LIME DOWN SOLAR PROJECT

DEADLINE 7 ADDITIONAL TRANSPORT SUBMISSION – STOP LIME DOWN

1. Cover Submission

Title: Figure 3-3: 400kV Substation and BESS Layout

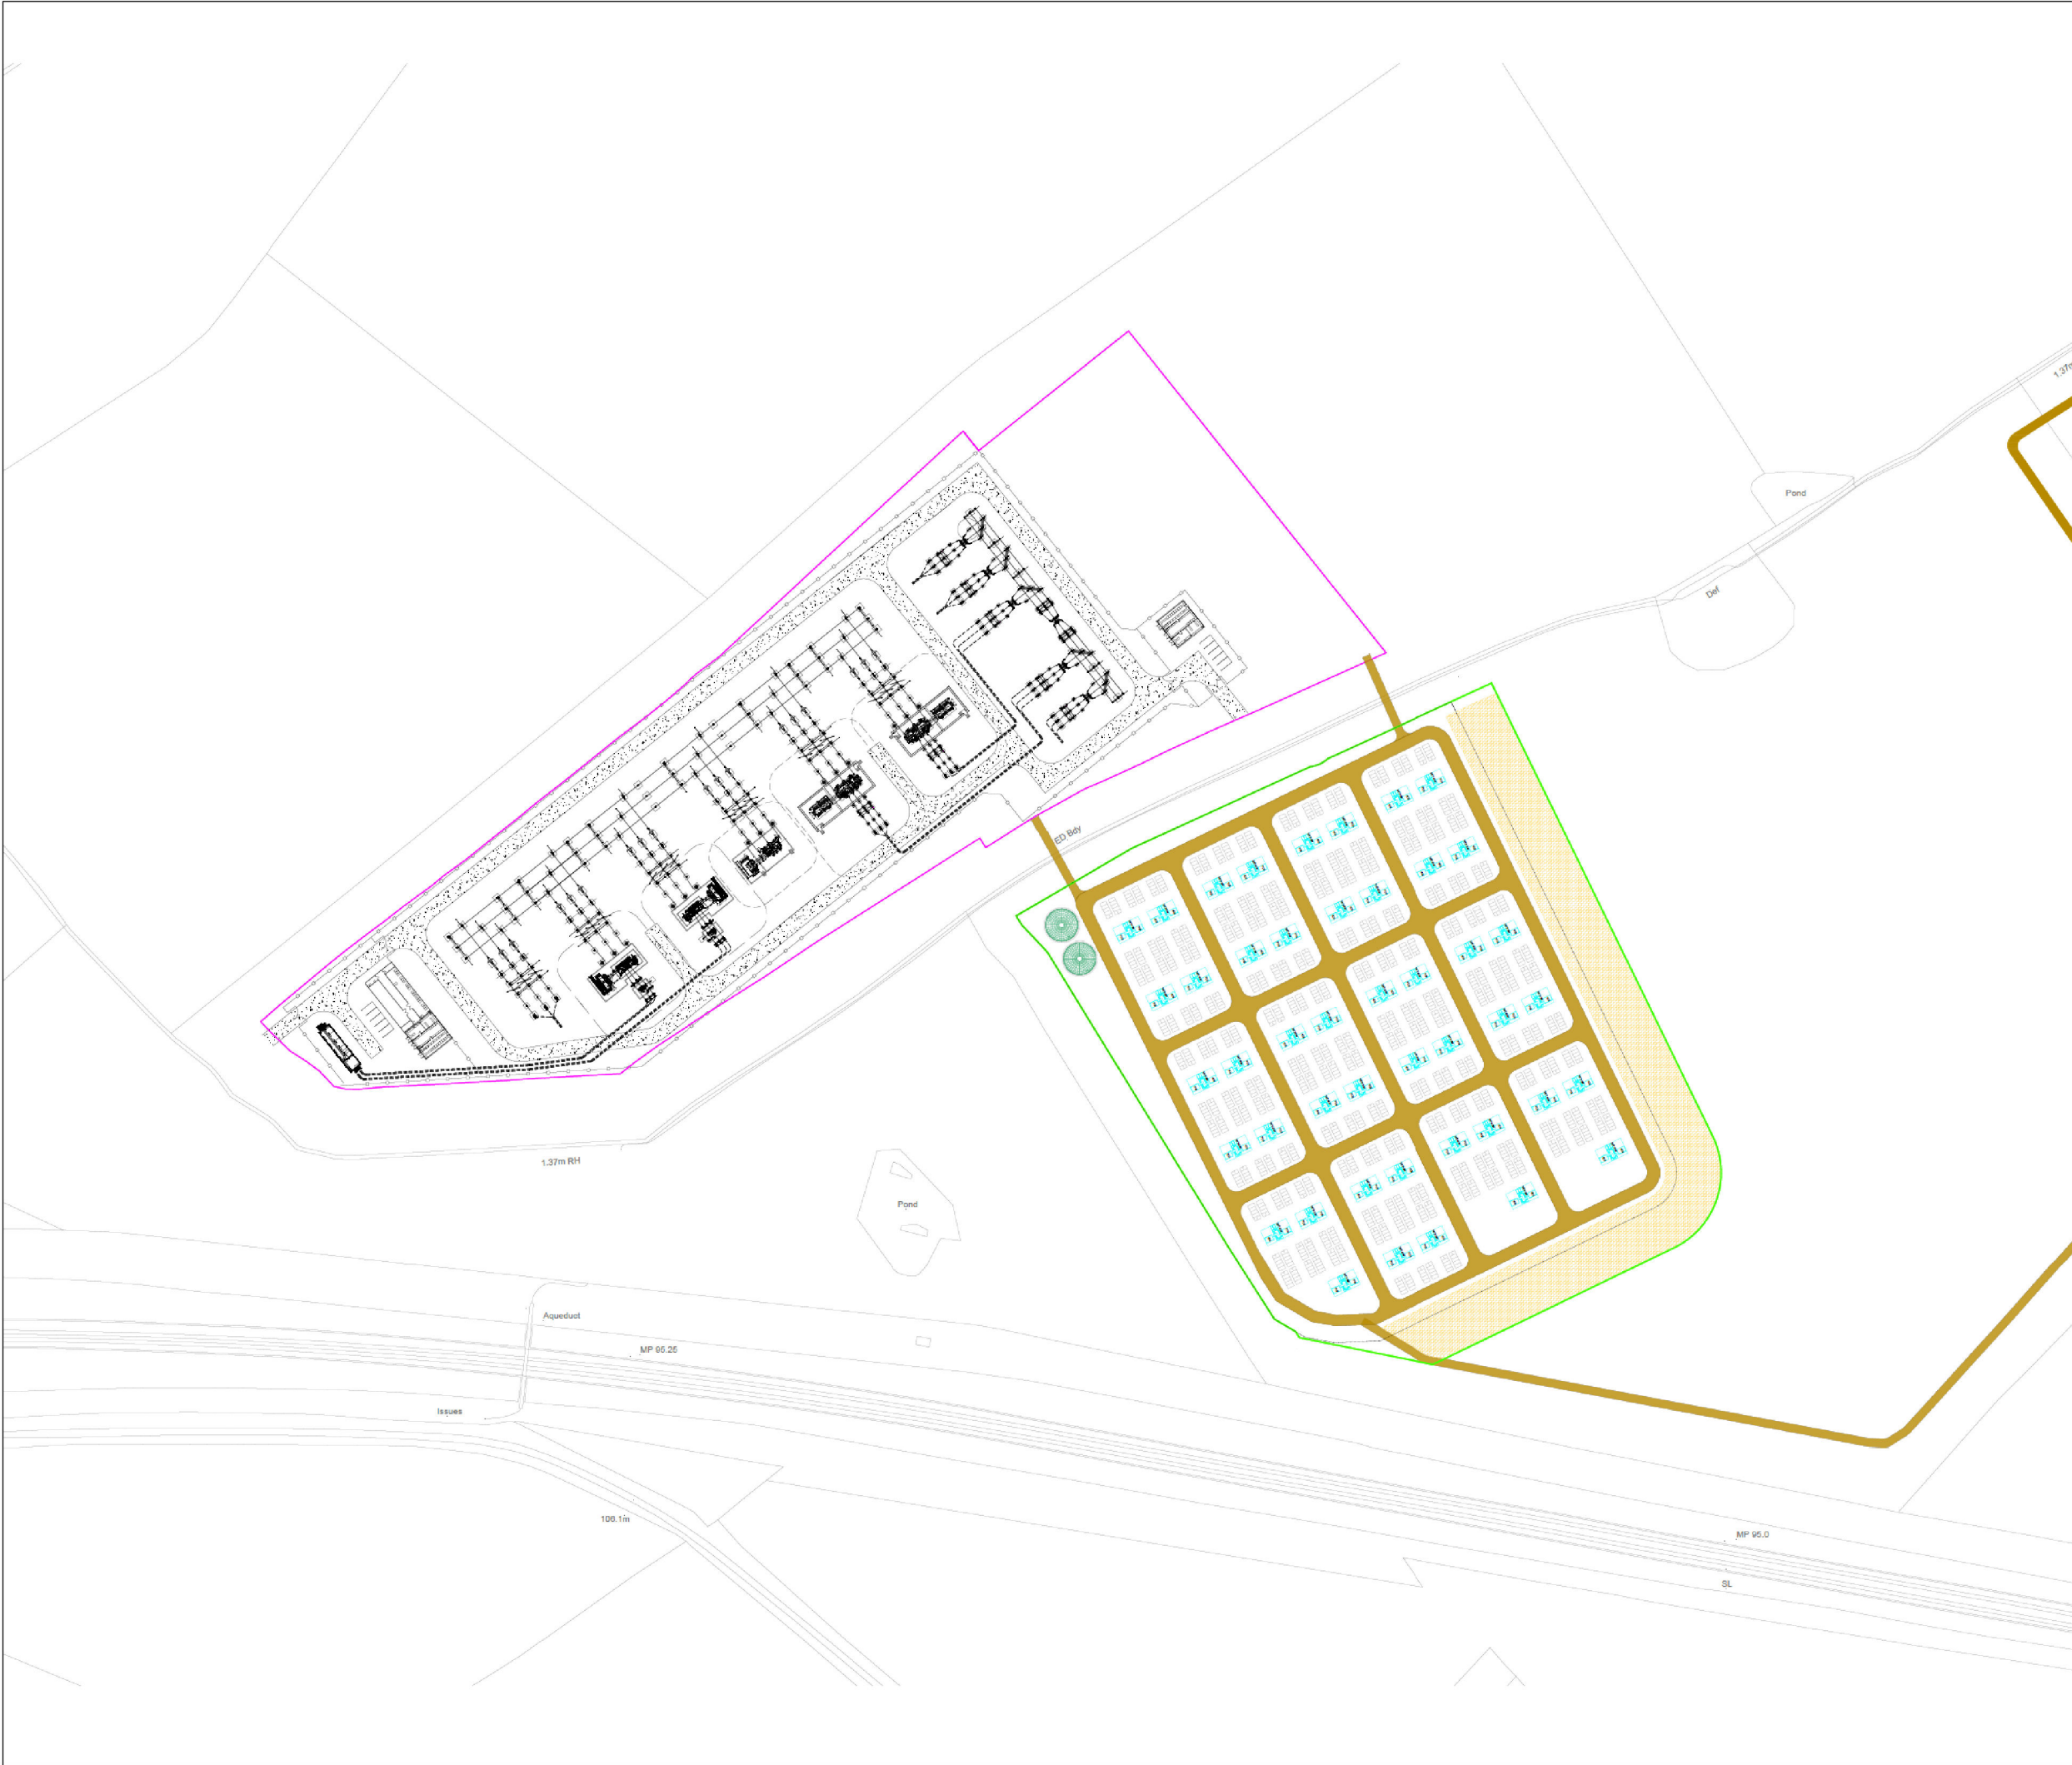
BESS/400kV Access Track	442 HGVs	The access track required to serve the 400kV Substation and BESS would be 0.9km in length. This will be designed to accommodate AIL vehicles delivering transformers to a 400kV substation. The access road will therefore be 6.0 metres wide,	553 HGVs	The illustrative design in Appendix 3-3 shows drainage ditches that, on a reasonable worst case basis are likely to need to be rock-filled or cemented to avoid collapse. A 25% allowance has been made for drainage infrastructure.

widening at bends with a compacted construction depth of 0.65 metres. There would be no requirement for passing places given the infrequency of movements. The Applicant now includes a 5% widening allowance as per Table 2 of Appendix A of Stop Lime Downs Deadline 4 Comments [REP4-132], which has been added to the trip generation calculations.		
132kV Access Tracks	700 HGVs	The access track required to serve the 132kV substations total 2.9km in length. This will be designed to accommodate AIL vehicles delivering transformers to a 132kV substation. Further information on the design parameters for 132kV Access tracks is now provided in the updated ES Volume 3, Appendix 3-3: Illustrative Drawings submitted at Deadline 5. This is in accordance with guidance from UKPN for access requirements to 132kV substations. The access road will therefore be 4.5 metres wide, widening at bends, with a compacted construction depth of 0.41 metres. The Applicant also includes a 5% widening allowance which has been added to the trip generation calculations.	700 HGVs	Agreed

5-axle SL2 Semi low loader trailer capable of delivering the BESS units is provided at Appendix C .		
BESS Power Conversion System (PCS)/transformer Units	45 HGVs	As confirmed by the supplier (see), each of the 45 integrated PCS/transformer units will comprise of a 40ft, 32 tonne container (12.192 Length x 2.438m Width x *2.896m Height) While an AIL (in terms of weight only), each unit will require one delivery vehicle. The size of AIL vehicle delivering the BESS units will be similar to a Max legal HGV. An example of a 7-axle SL2 Semi low loader trailer capable of delivering the PCS units is provided at Appendix D.	45 HGVs	Agreed
BESS Foundations	2,051 HGVs	The indicative size of the BESS area is 27,096m² (see Applicant Response to SLD's WR [REP3-133], para. 3.5.5). Both BESS and PCS units would sit on concrete platforms that would be supported on concrete piles. As per Table 2 of Appendix A of Stop Lime Downs Deadline 4 Comments [REP4-132] the Applicant has assume an average depth of concrete for BESS and PCS foundations of 0.8m. As per Table 2 of Appendix A of Stop Lime Downs Deadline 4 Comments [REP4-132] The Applicant has assumed that the entire BESS area will include the provision of a further impermeable concrete structure, likely to be filled with gravel. The Applicant has assumed a 0.3m depth of concrete and 0.3m of gravel over areas not occupied by BESS and PCS platforms.	2,051 HGVs	Agreed
